12 September 2018

File No: R/2017/23/A and R/2017/22/A
Our Ref: 2018/474366

SSD 8875 (Pitt Street North) and SSD 8876 (Pitt Street South) Over Station Development Concept Proposals

Figure 9 – Three contemplated construction scenarios in relation to construction of the integrated station development

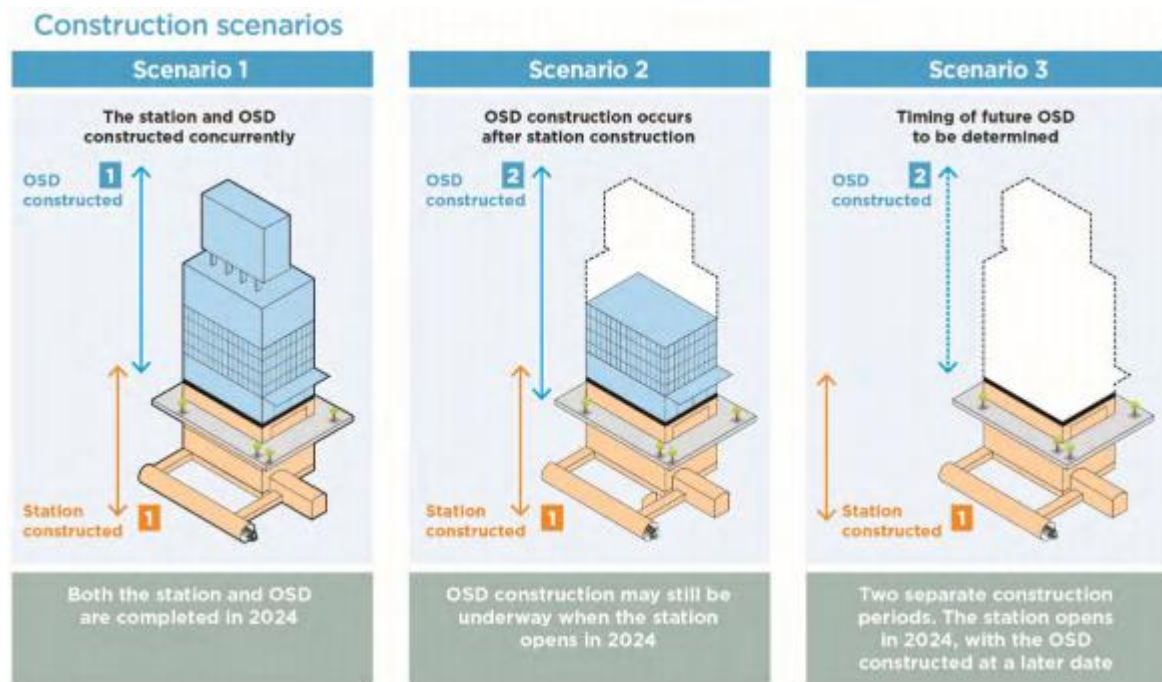
Any concerns by the proponent that a design excellence process in accordance with the provisions of Sydney LEP 2012 might extend the duration and completion of the OSD and station development directly contradicts the staging scenarios presented in both of the EIS documents and the Sydney Metro Pitt Street community handout.

Specifically, Option 3 suggests an approach where the station is constructed first with the OSD built at a later stage (refer extract below). It is entirely feasible that a design excellence competition can be completed without impacting on timelines already contemplated by the proponent for the delivery of the projects.

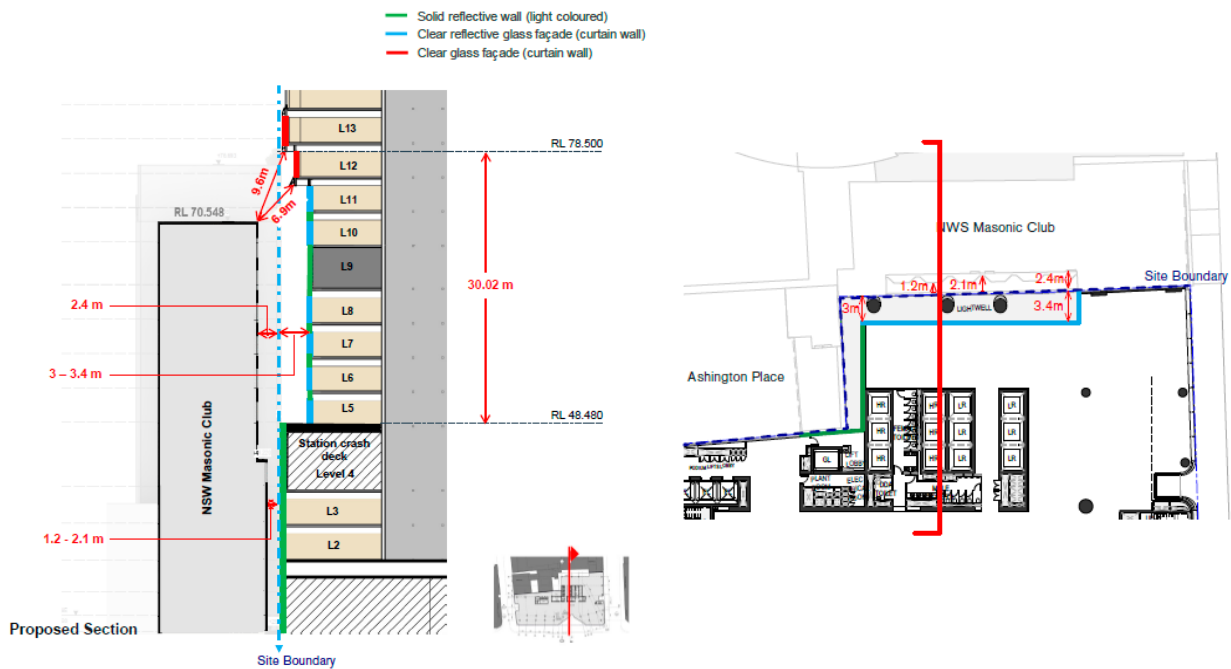
For the Pitt Street North development, the building envelope footprint along the northern boundary should be modified to match the existing “indent” of the NSW Masonic Club building (169-173 Castlereagh St).
